Subject: Planning application 3/2021/0172

I would like to comment and raise my objections to any further changes to the King's Cocktail Bar.

PROPOSED FIRST FLOOR PLAN
SCALE 1:100

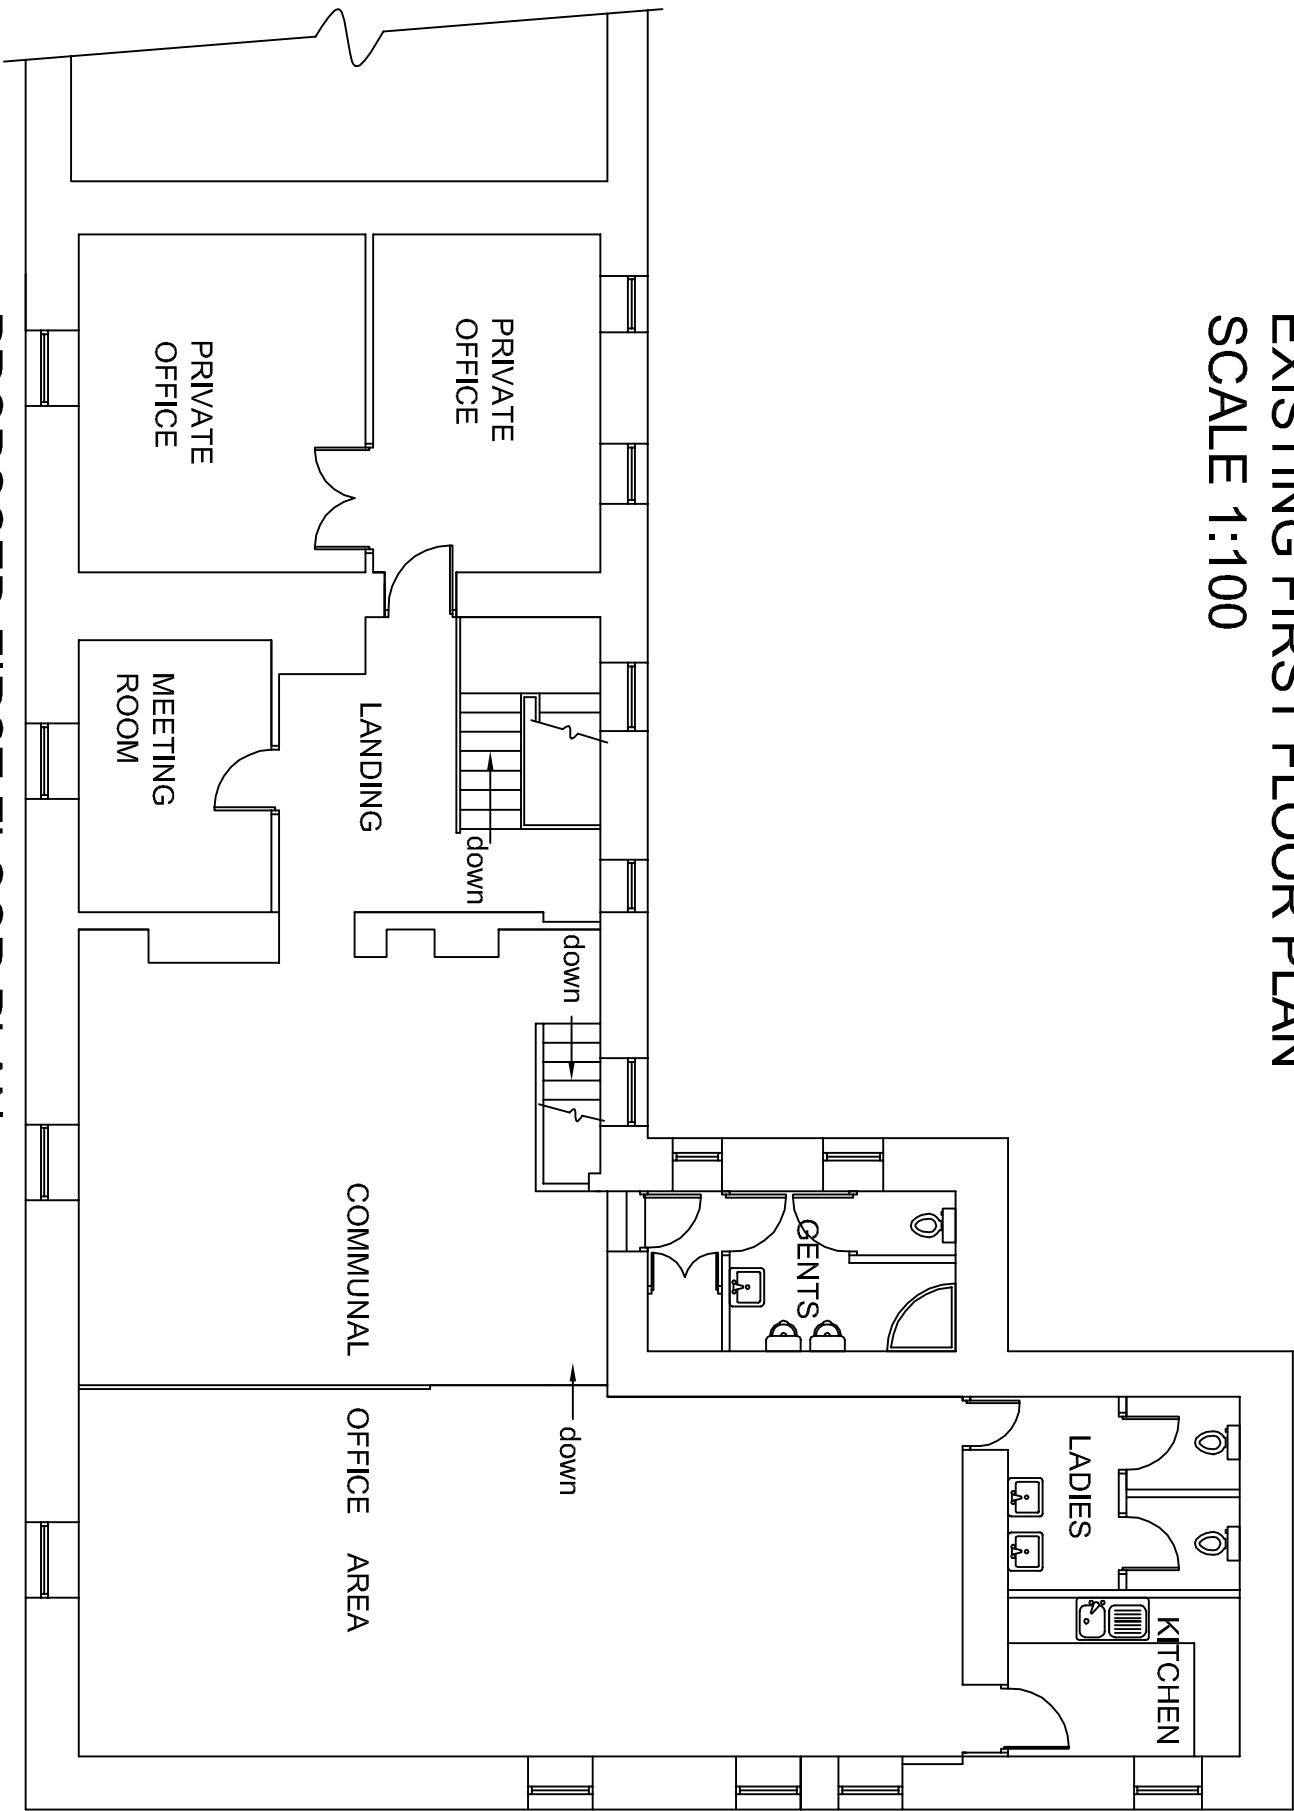
The first floor flat overlooks our garden area which is nothing to do with the pub. The pub has already managed to build in arrears that were refused planning twice because of the detrimental affect it would have being so close to us. An office means members of the public will be overlooking our private gardens.
